EPPING PARK: STAGE 2 – BUILDING 9

ACCESS REVIEW

Morris-Goding Accessibility Consulting

20th June 2011

1 GROUND FLOOR PLAN
1 : 100

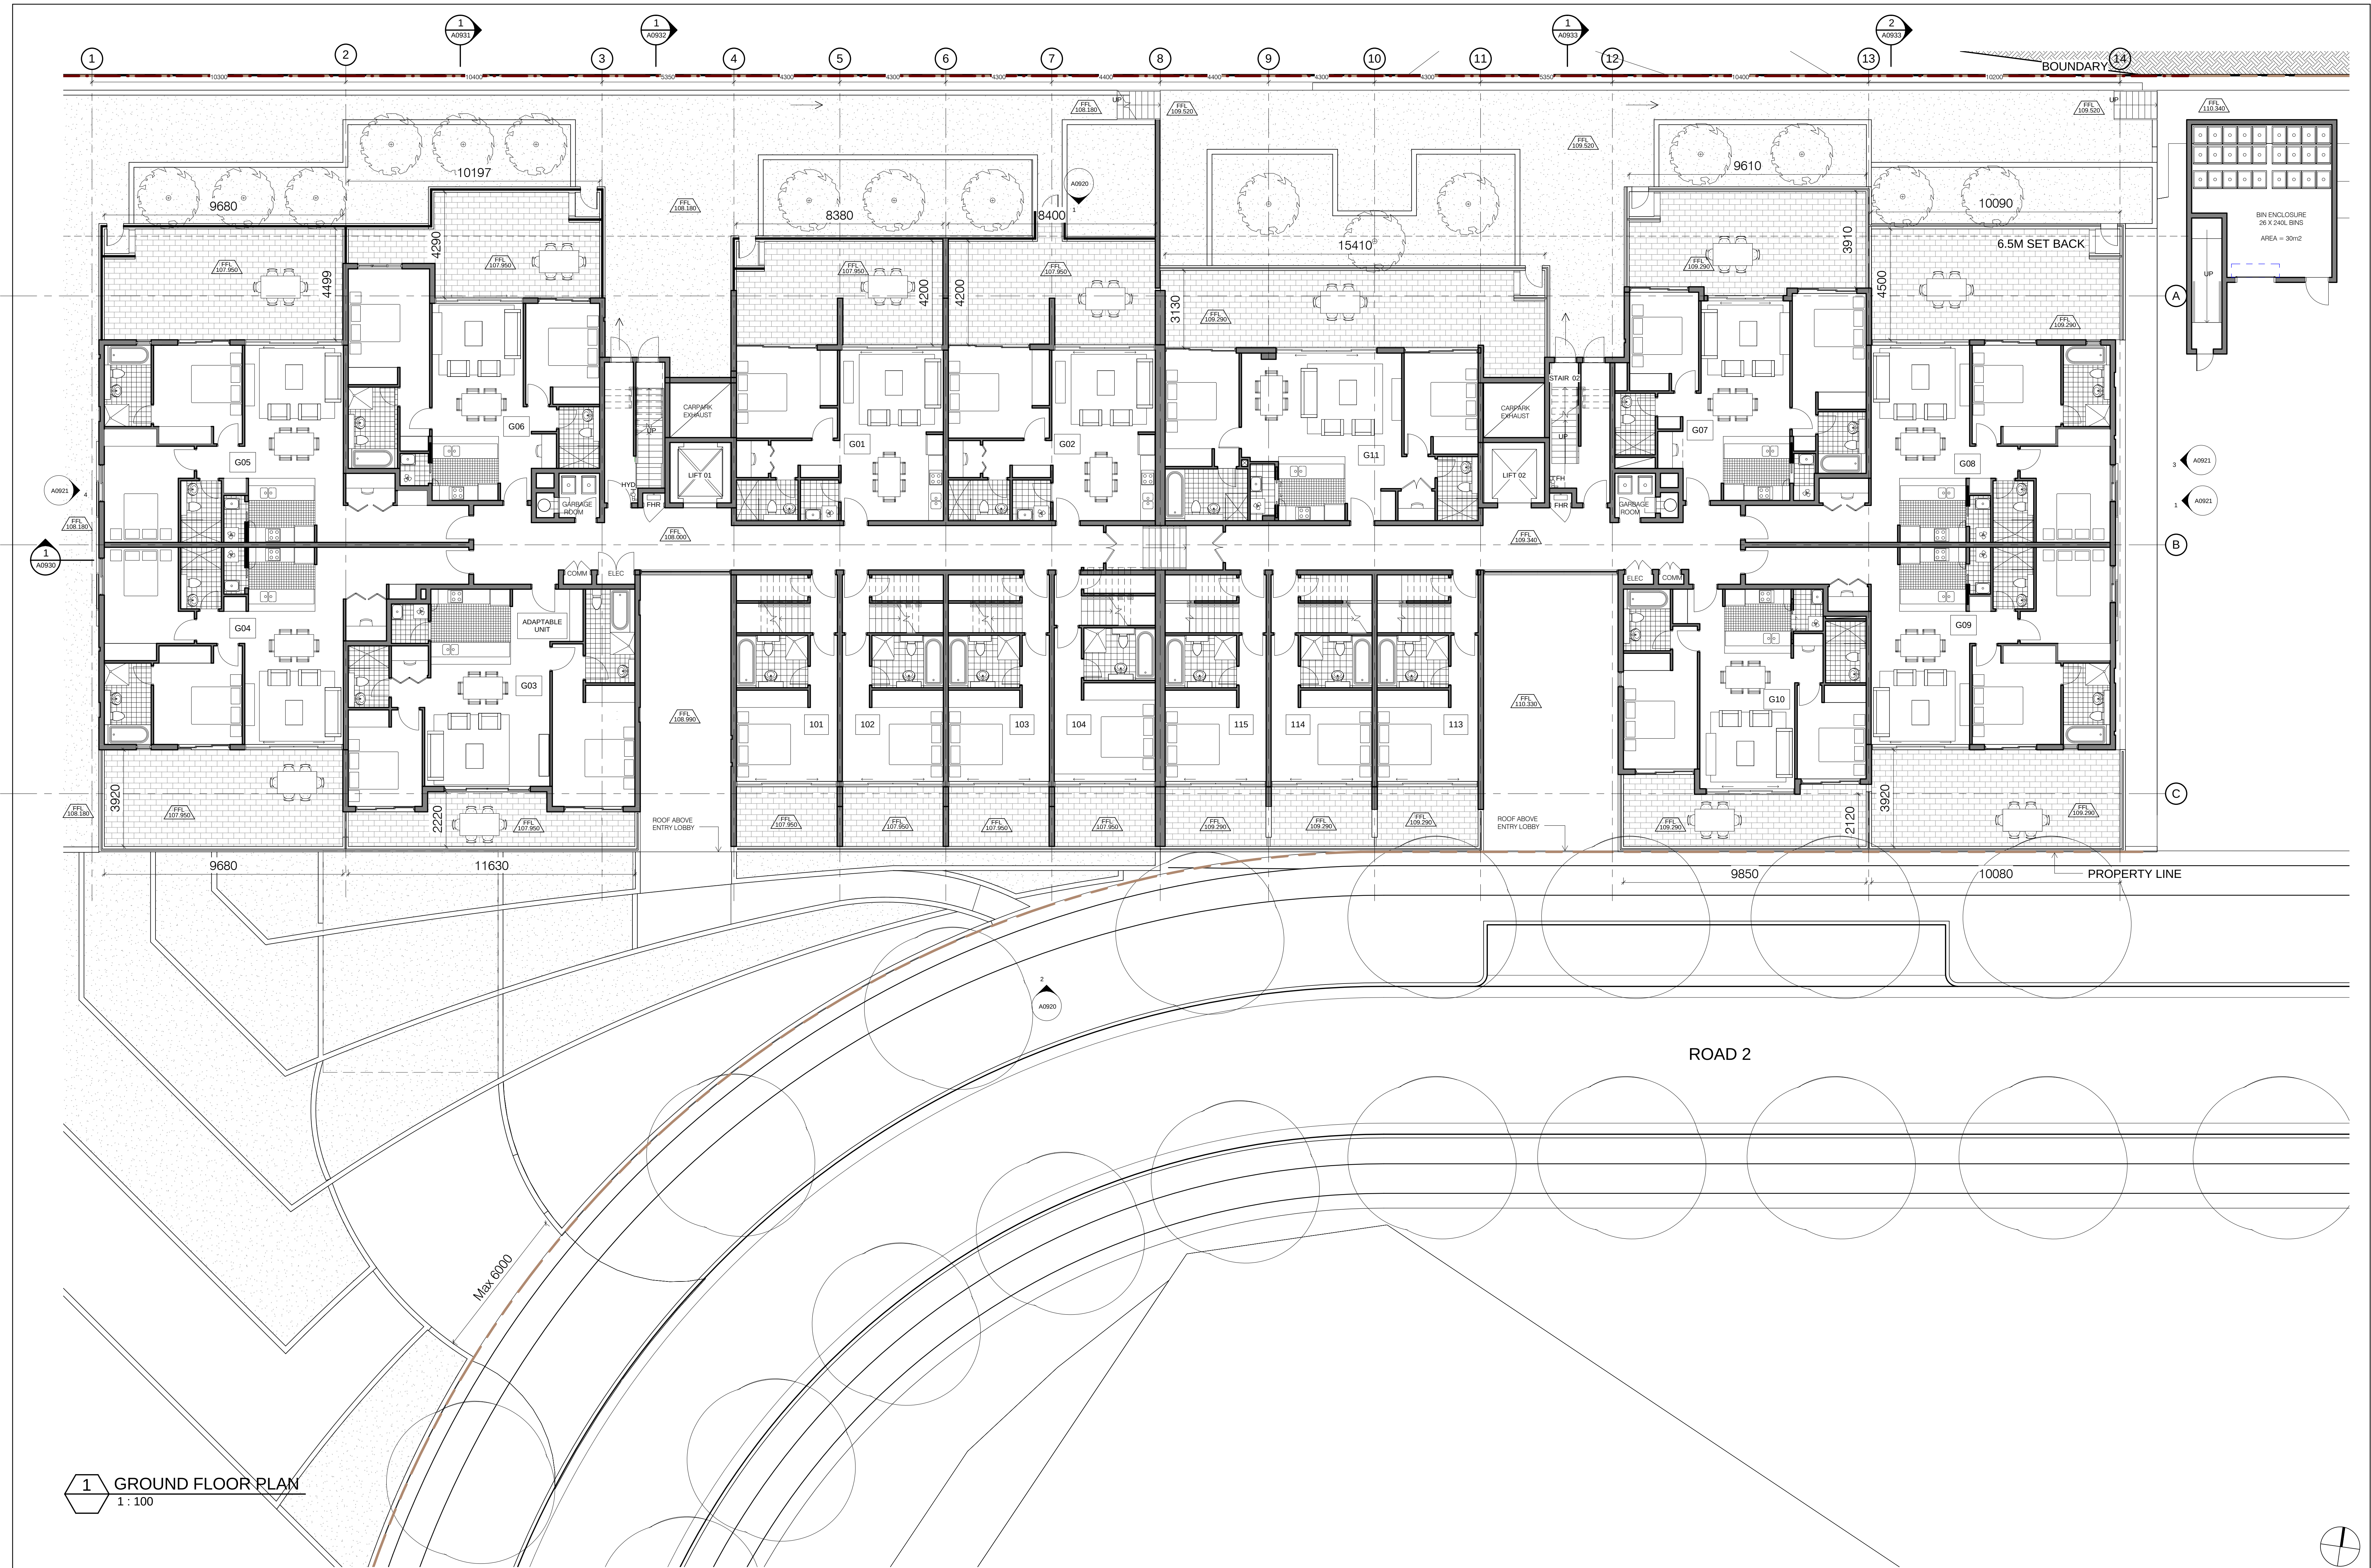
There is an accessible path of travel from the pedestrian footpath near Road 2 to entry of Lobby 1 compliant with AS1428.1:2009, clause 6.1. The entry lobby has a clear width of 3650mm suitable for two people in a wheelchair to pass one another in accordance with AS1428.1:2009.

There is suitable clearance for the future inclusion of an AS1428.1:2009 compliant doorway. From the entry, there is an accessible path of travel to the lift lobby area in accordance with AS1428.1:2009, clause 6.1. The circulation areas in front of the passenger lift are appropriate for a person in a wheelchair in accordance with the DDA Premises Standards.

- (i) Ensure the entry doors have a minimum 850mm clear width and 510mm latch side clearance suitable for wheelchair manoeuvrability in accordance with AS1428.1:2009.

From the pedestrian footpath near Road 2, there is an accessible path of travel to the Lobby 2 residential entrance compliant with AS1428.1:2009, clause 6.1. The entry lobby area has a clearance of 5460mm clear width which is suitable for wheelchair manoeuvrability in accordance with AS1428.1:2009.

There is an appropriate clearance to allow for an AS1428.1:2009 compliant doorway. There is suitable clearance in front of the lift lobby suitable for two wheelchair users to pass one another in accordance with the DDA Premises Standards.

- (i) Ensure the entry doors have a minimum 850mm clear width and 510mm latch side clearance suitable for wheelchair manoeuvrability in accordance with AS1428.1:2009.

Within the central corridors of ground floor, level 2 and level 4, there are internal stairs which link lobby 1 and lobby 2. The fire doors have a 620mm clear width. It is unclear if these stairs are to be used as communication stairs.

- (i) Corridor entry doors to have 850mm clear widths compliant with AS1428.1:2009.
- (ii) If stairs are to be used as communication stairs, they will require handrails along both sides and TGSIs compliant with AS1428.1:2009.

1 LEVEL 1 FLOOR PLAN
1: 100

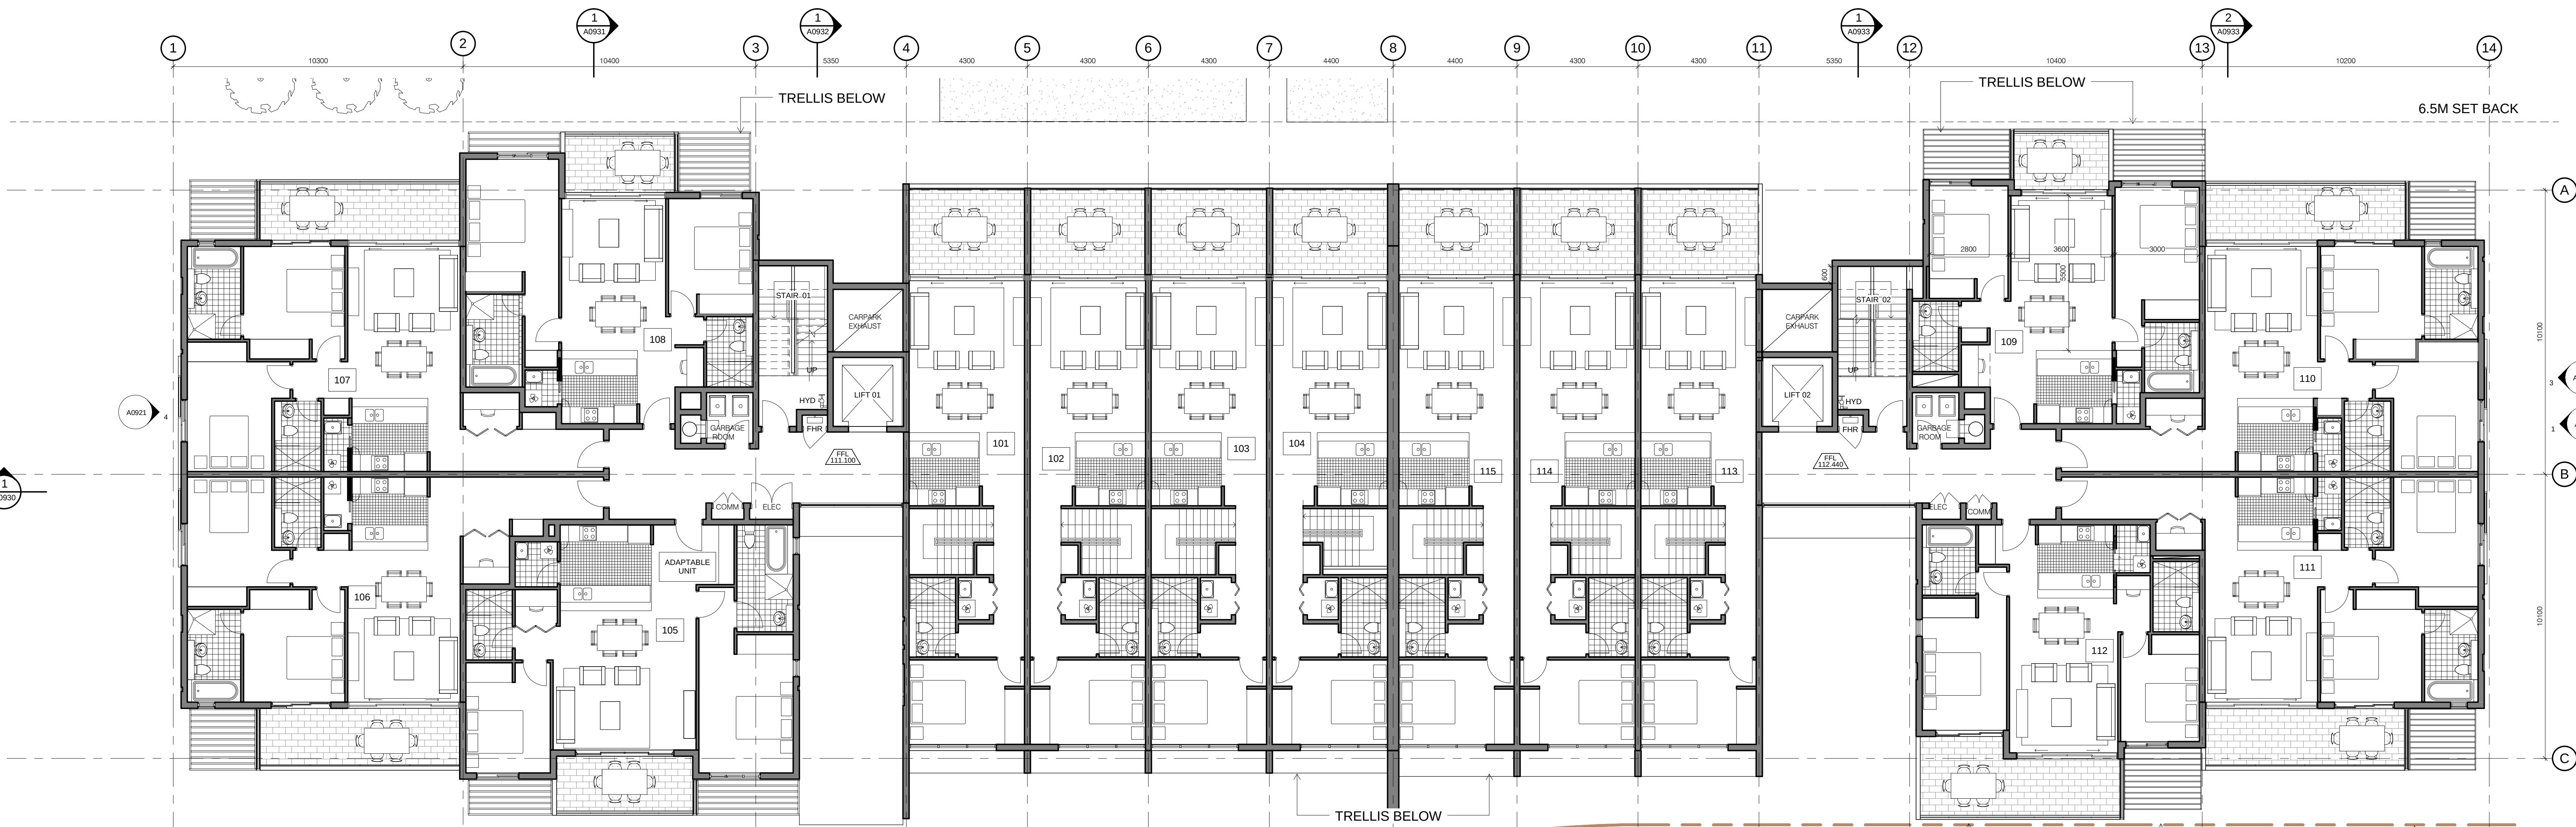
5.2. Adaptable Unit Type 1: Units G03, 105, 203, 305, 403 and 505

Entry into the adaptable unit is via a 920mm clear width entry door with a 790mm latch side clearance compliant with AS4299. The door has appropriate external circulation compliant with AS4299.

The accessible ensuite has a 920mm clear width door. The door has a 460mm latch side clearance. The toilet has internal dimension of 1950mm x 3780mm which will need to be enlarged to ensure an appropriate circulation area around the pan, basin and shower recess.

The laundry has a 715mm clear width door. There is insufficient internal latch side clearance provided. The laundry has a 1000mm clearance in front of laundry appliances non-compliant with AS4299.

- (i) The accessible ensuite door requires a minimum 510mm latch side clearance compliant with AS1428.1:2009.
- (ii) Bathroom (shower, toilet, wash basin) to comply with circulation area requirements of AS1428.1:2009, that is provide an area of 1900mm x 2300mm around the pan. The wash basin should sit outside this area, and if needed only encroach into this area by 100mm (max). The shower area requires 2500mm x 1600mm. An internal dimension of 2.3m x 2.7m will satisfy this requirement.
- (iii) Laundry door to have a minimum 850mm clear width and 510mm latch side clearance on the internal leaf suitable in accordance with AS1428.1:2009.

- (iv) The laundry requires a minimum 1550mm turning circle in front of laundry appliances compliant with AS4299.

2 LEVEL 5 FLOOR PLAN
1:100

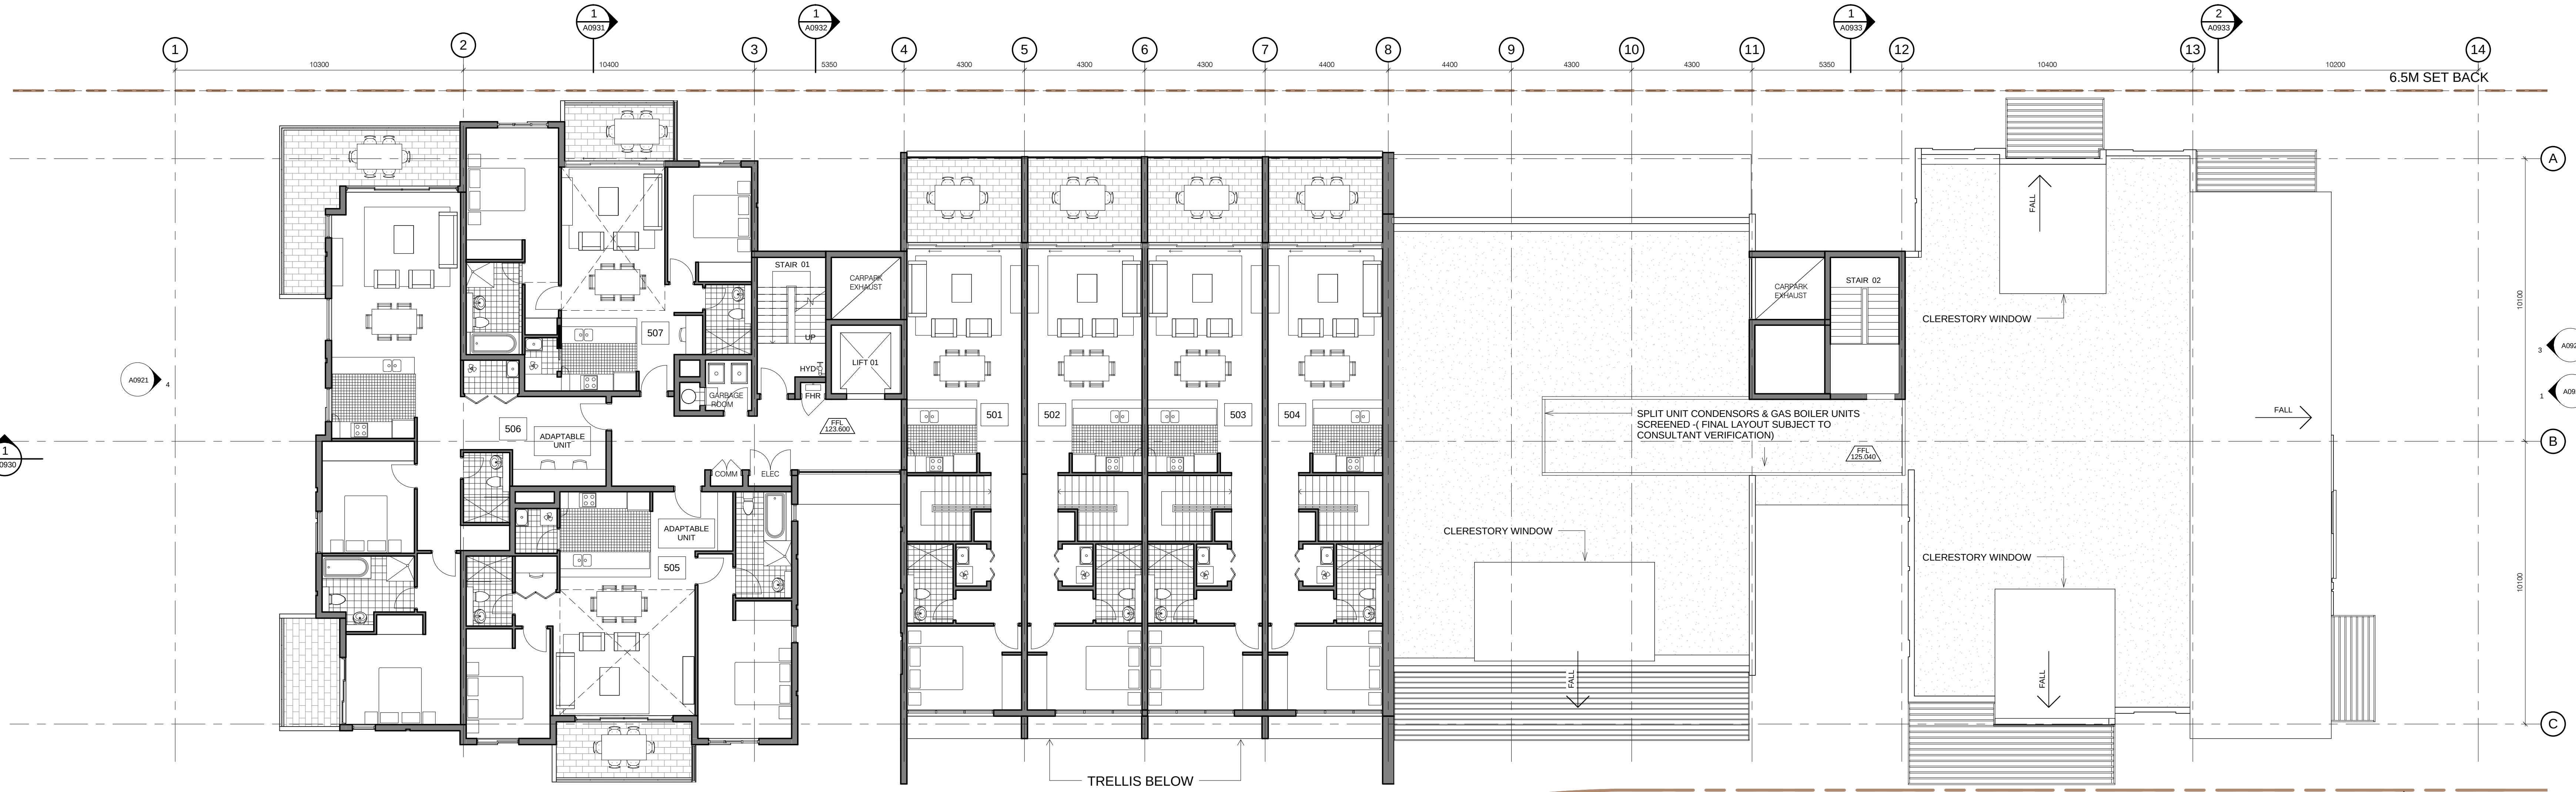
5.3. Adaptable Unit Type 2: Units 404 and 506

The accessible ensuite has a 710mm clear width door. A doorway compliant with AS4299 and AS1428.1:2009 is achievable. The accessible ensuite has internal dimension of 1993mm x 3290mm outside the basin area compliant with AS1428.1:2009.

- (i) The accessible ensuite door requires a minimum 510mm latch side clearance compliant with AS1428.1:2009.
- (ii) Bathroom (shower, toilet, wash basin) to comply with circulation area requirements of AS1428.1:2009, that is provide an area of 1900mm x 2300mm around the pan. The wash basin should sit outside this area, and if needed only encroach into this area by 100mm (max). The shower area requires 2500mm x 1600mm. An internal dimension of 2.3m x 2.7m will satisfy this requirement.
